APPLICATION NO: 20/01000/FUL/ADDINF

DESCRIPTION: Erection of first floor extension, two storey extensions to rear and side, single storey side extension and canopy to front.

LOCATION: Delrena The Splash Warfield

Title:  
**Proposed  
Elevations**

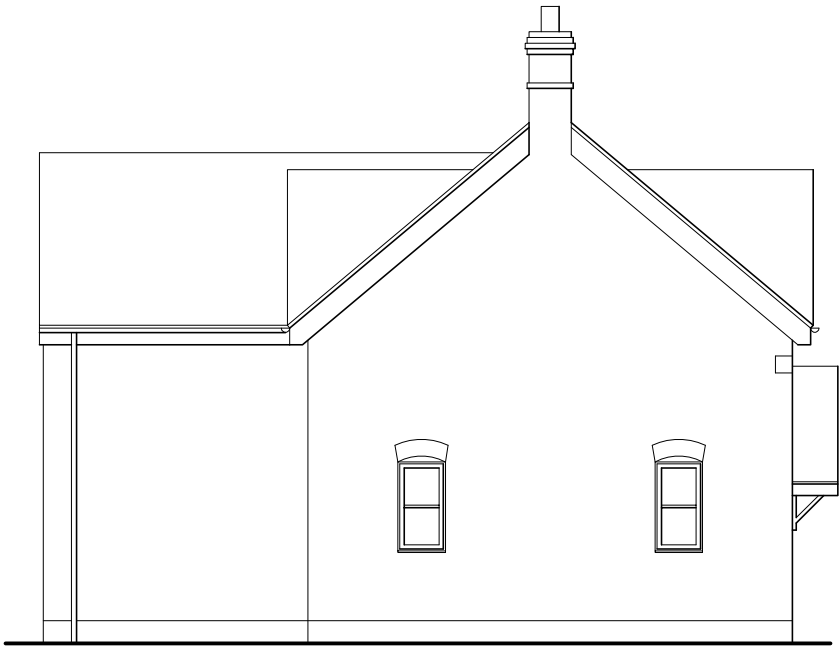
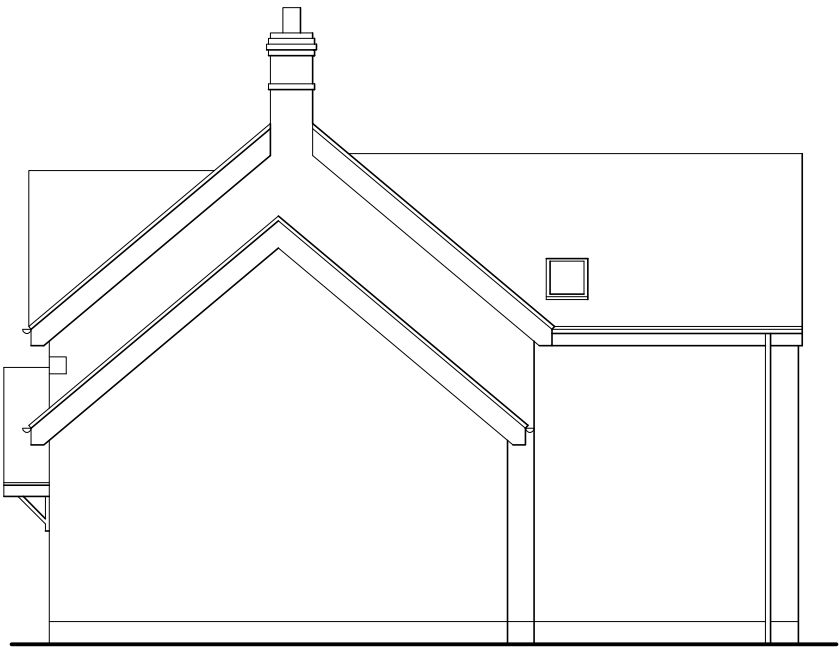
- 1 The single storey side extension shown on the elevations appears incomplete. Please could you amend the drawings to show.
- 2 Please confirm that none of the proposed development (including roof overhang) will encroach onto the neighbouring property. If your proposed development encroaches onto the neighbouring property you are required to serve notice, in addition to this you will be required to submit an amended section 25 (Certificate B) of the application form to reflect this.
